E19/7567/HH/009

21 November 2024

Re: Development off Lingards Road, Slaithwaite for SB Homes.

This letter has been prepared as a response to the S38 Stage 2 Road Safety Audit undertaken by Meraki Alliance. Each problem raised by the Road Safety Audit has been listed, along with the recommendations and our designers response:

Dwn	Chkd	Date	Scale	Dwg No.
HH		AUG-23	1:500@A1	E19/7567/022F

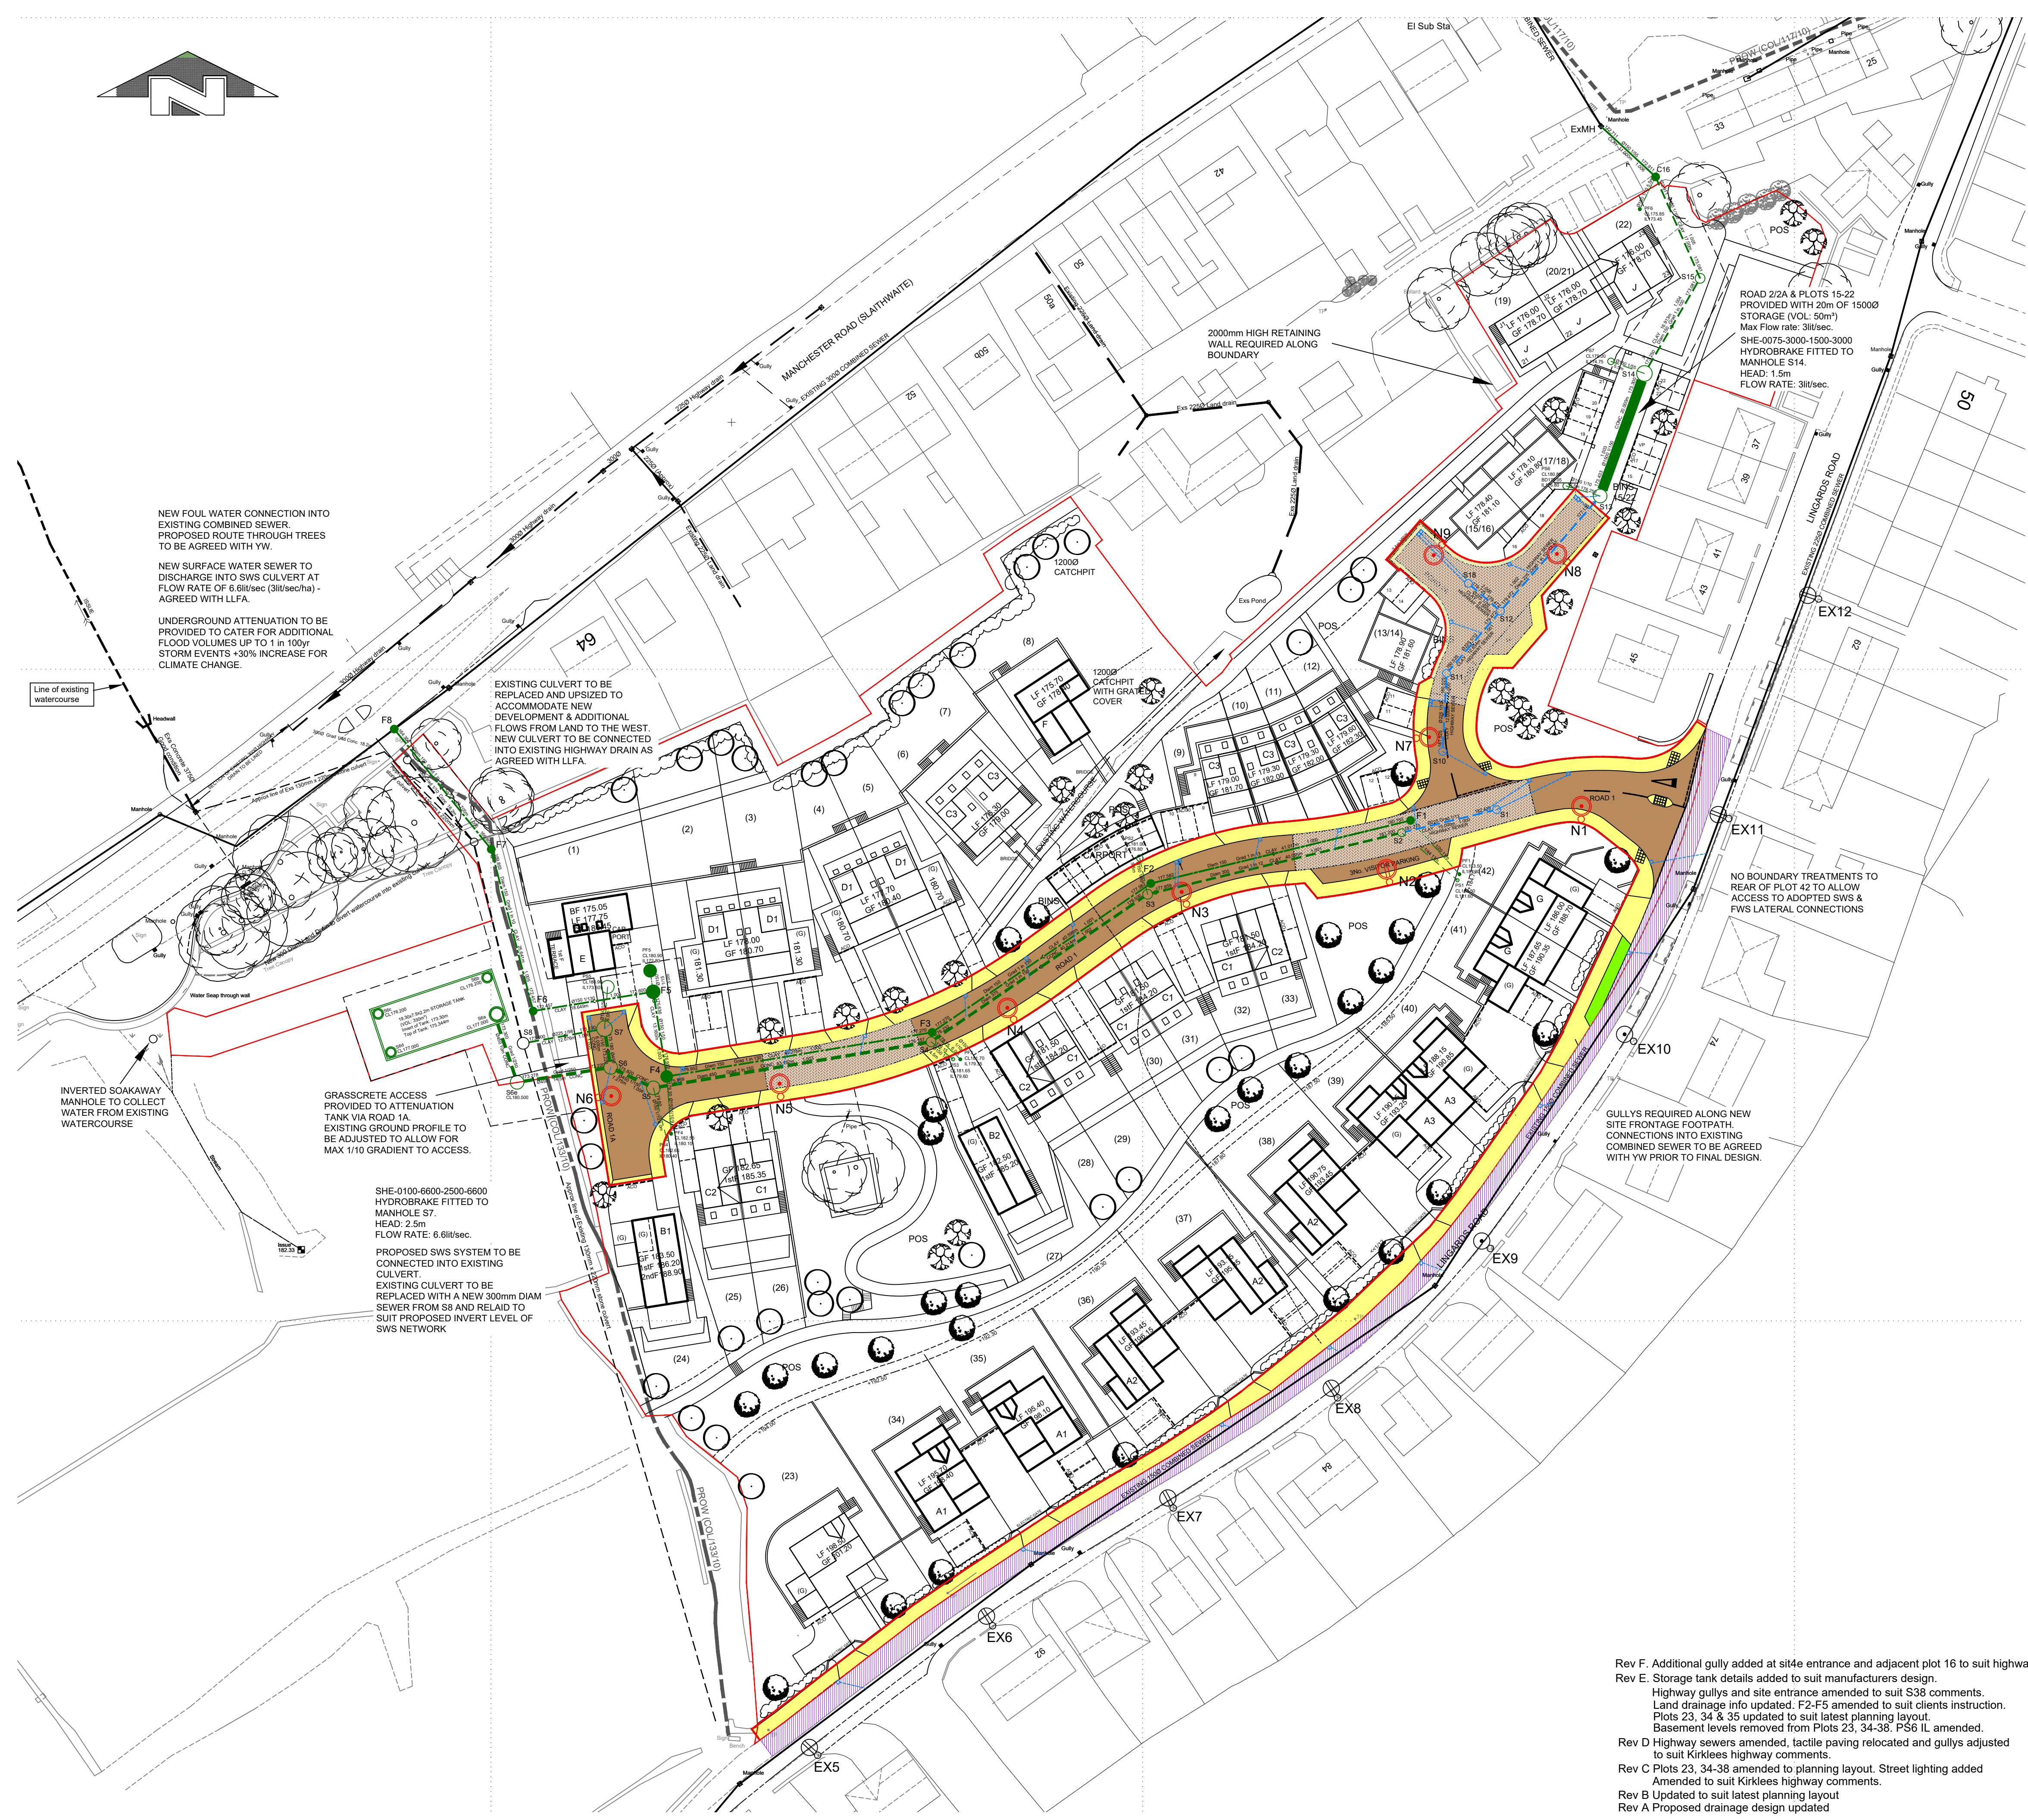
Problem – 2-2 – Uncontrolled crossing access junction.

Summary: *Obstructed visibility between pedestrians on the crossing and approaching vehicles will increase the risk of pedestrian/vehicle collisions.*

An uncontrolled crossing is proposed at the new site access junction which is slightly inset. The Audit Team considered that the position of the crossing could lead to physical features around the junction (hedge/trees) blocking intervisibility between pedestrians on the crossing and approaching vehicles. DMRB CD 109 states that visibility at uncontrolled crossings is measured 1.5m back from the edge of carriageway with a splay appropriate for the speed of approaching vehicles tuning into the development. Obstructed visibility will increase the risk of pedestrian/vehicle collisions.

Recommendation: *It is recommended that visibility splays of at least 1.5m x 40m are provided and if these cannot be provided without obstruction then the crossing will need to be moved.*

Designers Response: *As the 1.5m x 40m visibility splay could not be provided at the current crossing positions, it was agreed to move the crossing forward and introduce a central refuge island at the access entrance to help reduce the crossing distance to below 10m whilst ensuring the natural pedestrian desire line is maintained in accordance with Local Transport Note 2/95 The design of Pedestrian Crossings. Please refer to drwg no. 7567/022E for reference.*
